Project Name: \_\_\_\_\_  
 Tax Schedule Number (s): \_\_\_\_\_ \$ 1,837  
 File #: PPR-17-007

Subject: Monument Hill Business Park, PPR-17-007, Review 3

**EL PASO COUNTY PLANNING AND COMMUNITY DEVELOPMENT DEPARTMENT**

SHEET NUMBER
C2.1
SHEET 2
PROJECT NUMBER
1704.01

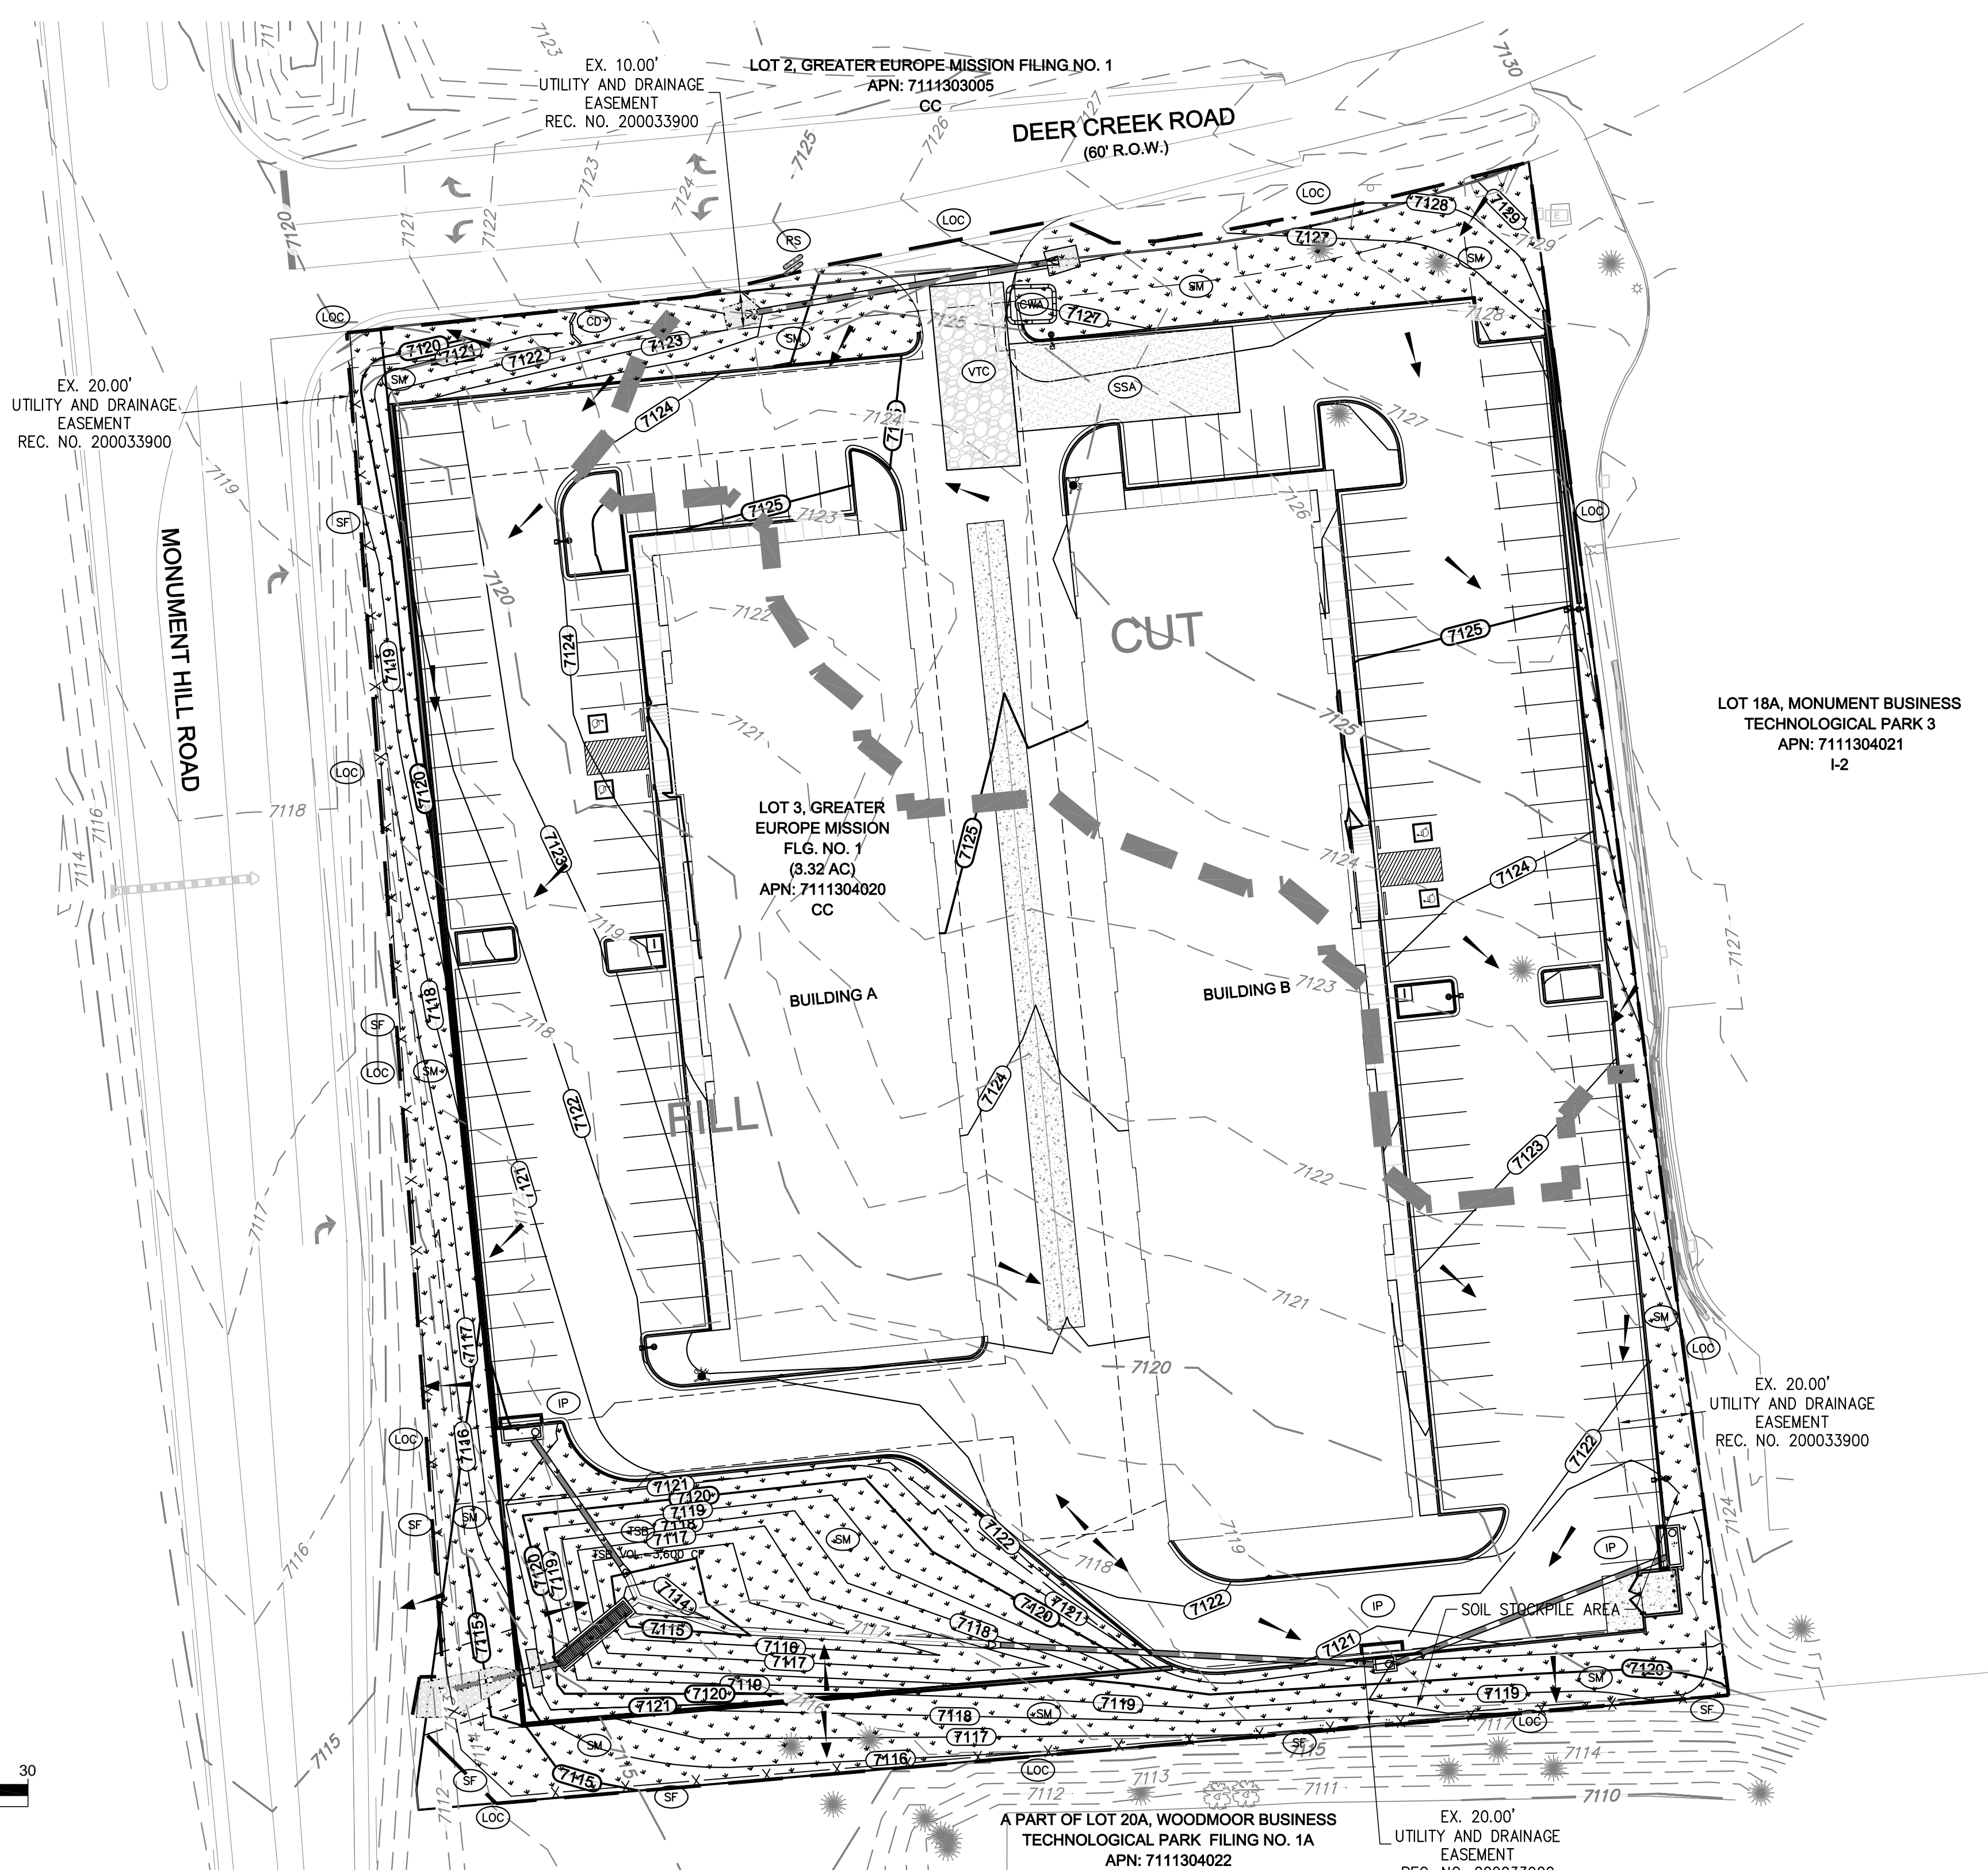
**Note added.**
26. In Sheet C2.1, add the inlet protection (IP) symbol next to the inlet at the southeast corner of the property.  
**Added.**
27. Adjust the grading at the western side of the driveway so there isn't 30 feet of exposed culvert pipe.

3 OF 8

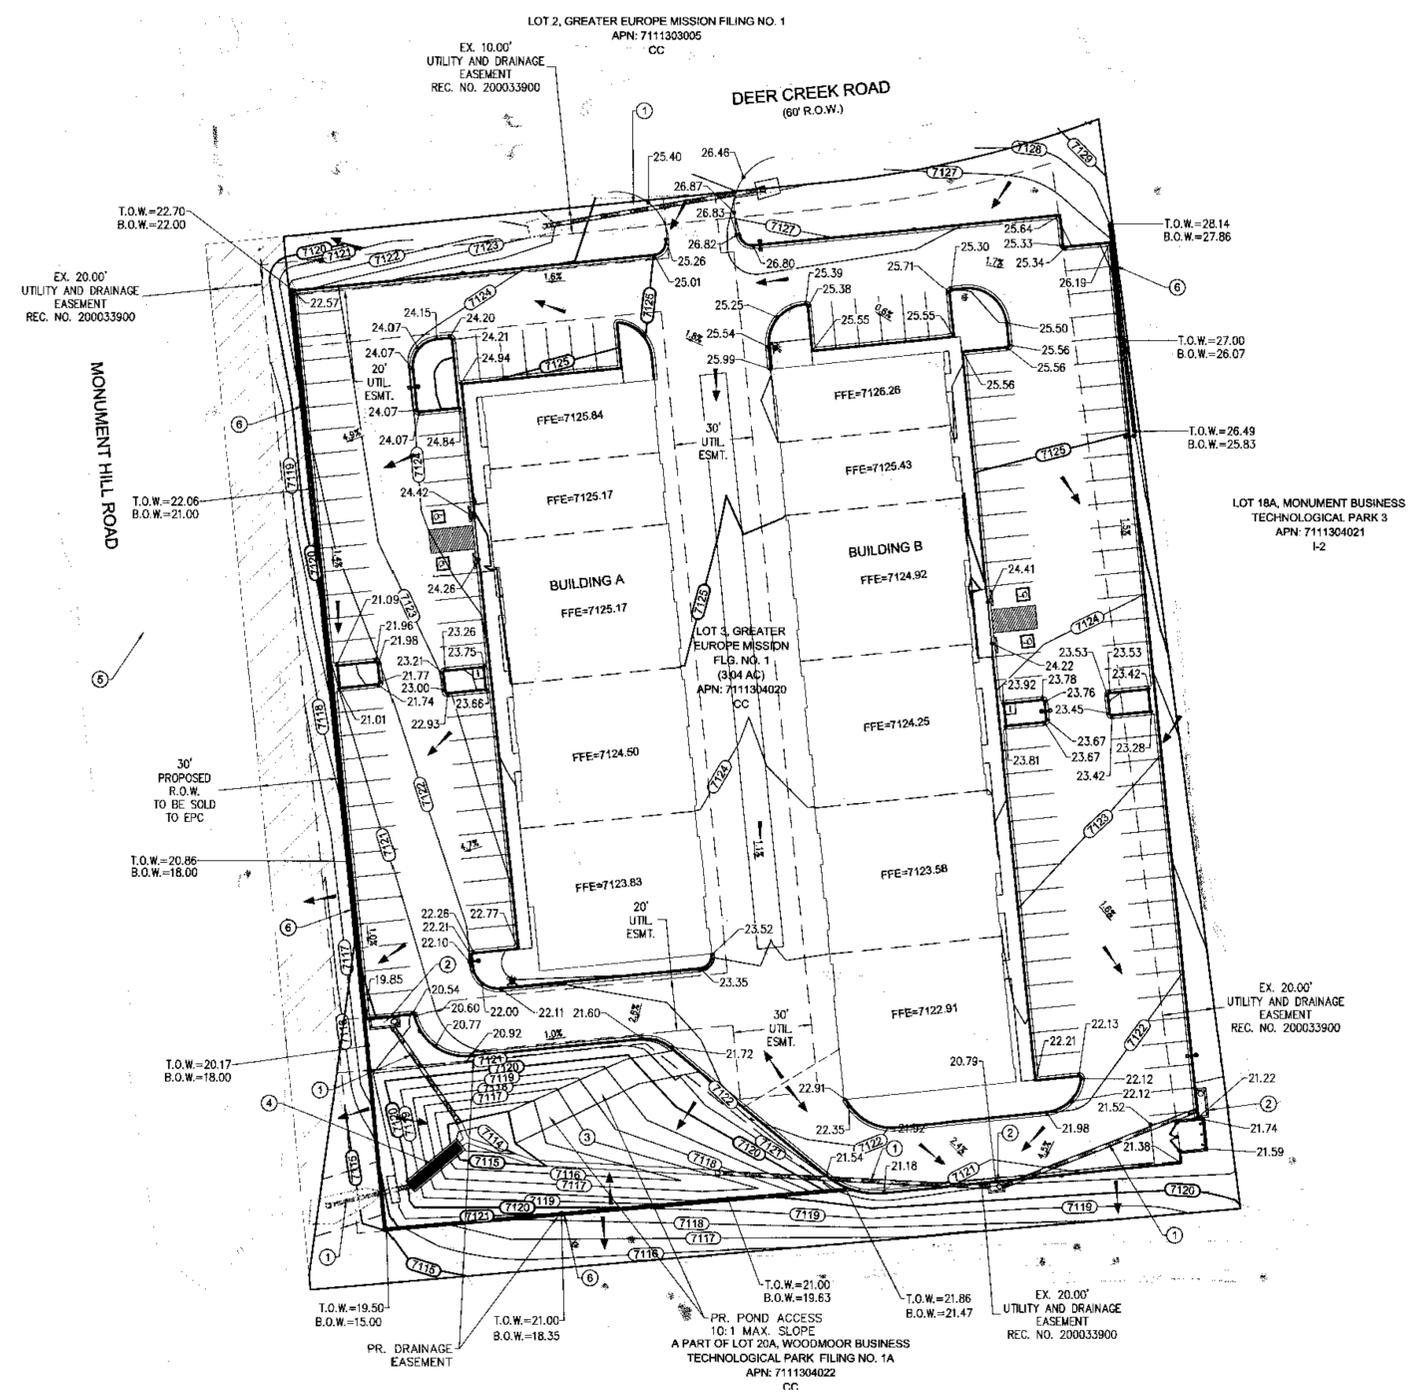
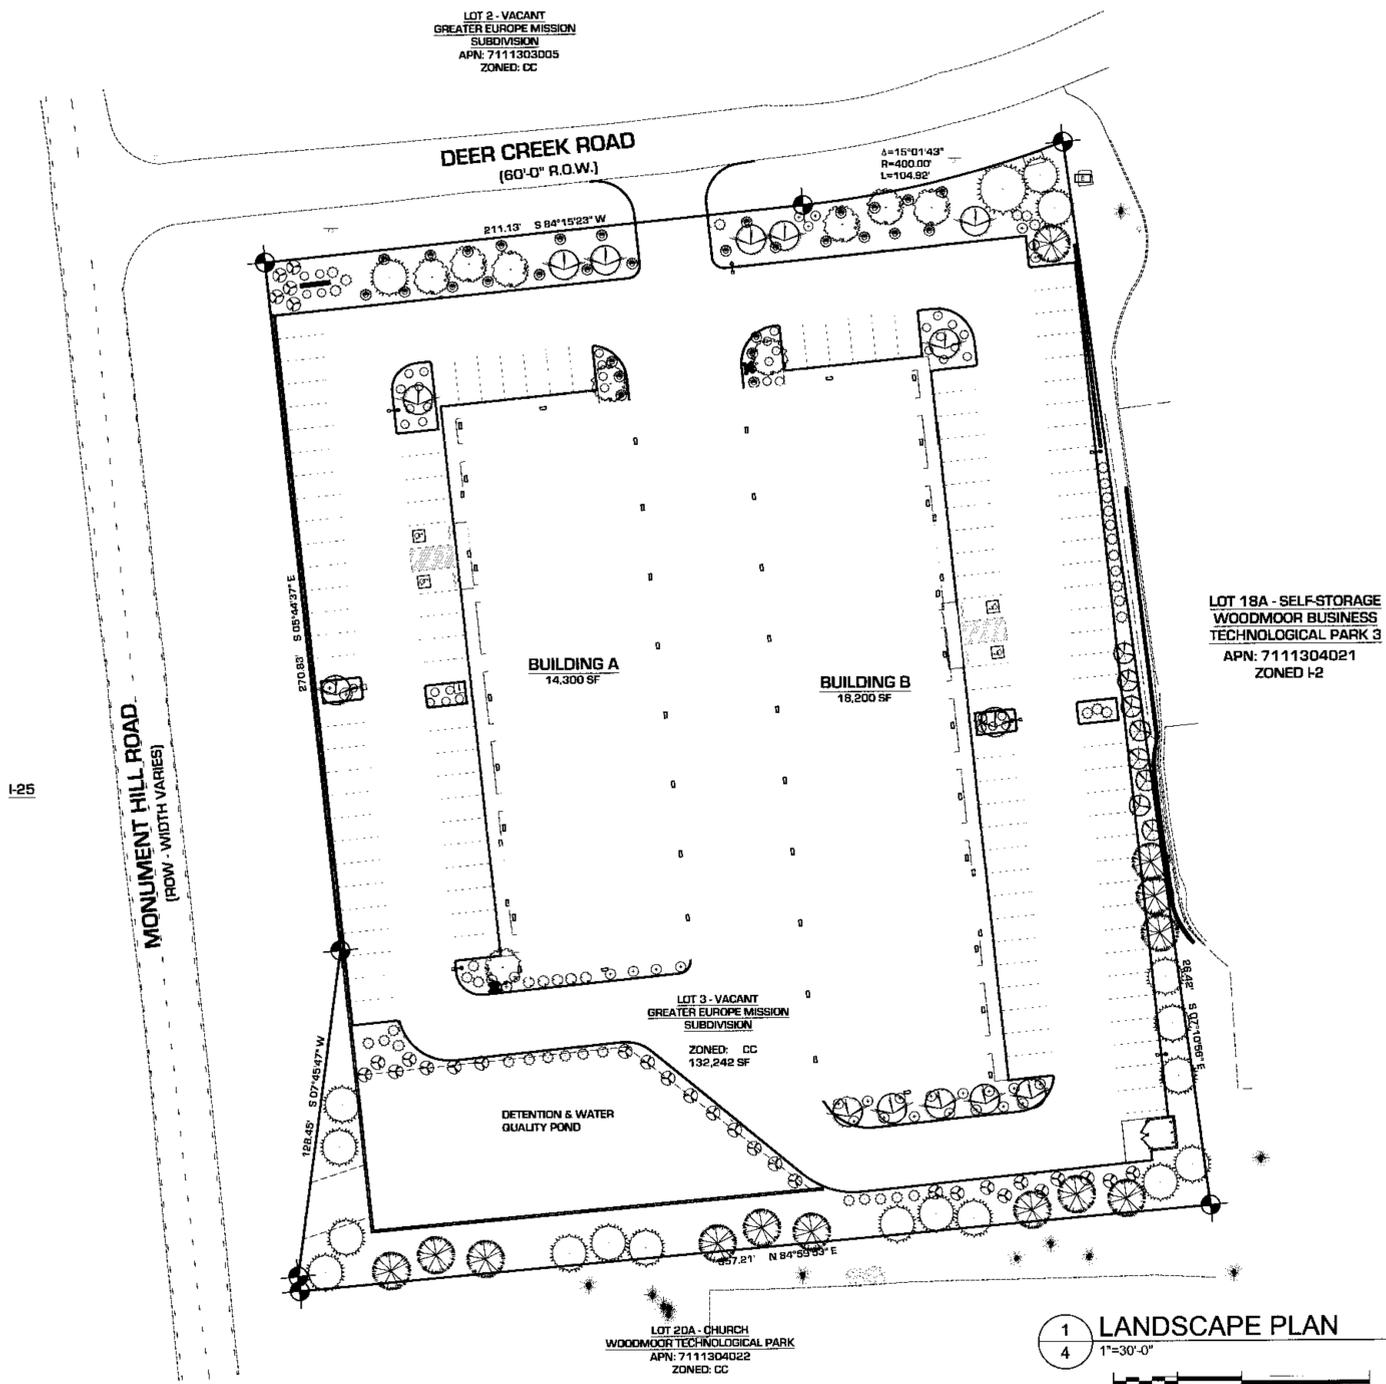
1. Resolved.
2. Resolved.
3. The retaining wall at the southwest corner of the site is greater than 4 ft in height. A building permit may be required. Contact Regional Building Department for their requirement.  
**Noted. RBD will be contacted for the necessary permit.**
4. Adjust the grade slopes at the handicap parking stalls west of Building A so it does not exceed 2% in any direction per ADA.  
**The grading at the ADA spaces on the west side of Bldg A have been adjusted to not exceed 2%.**
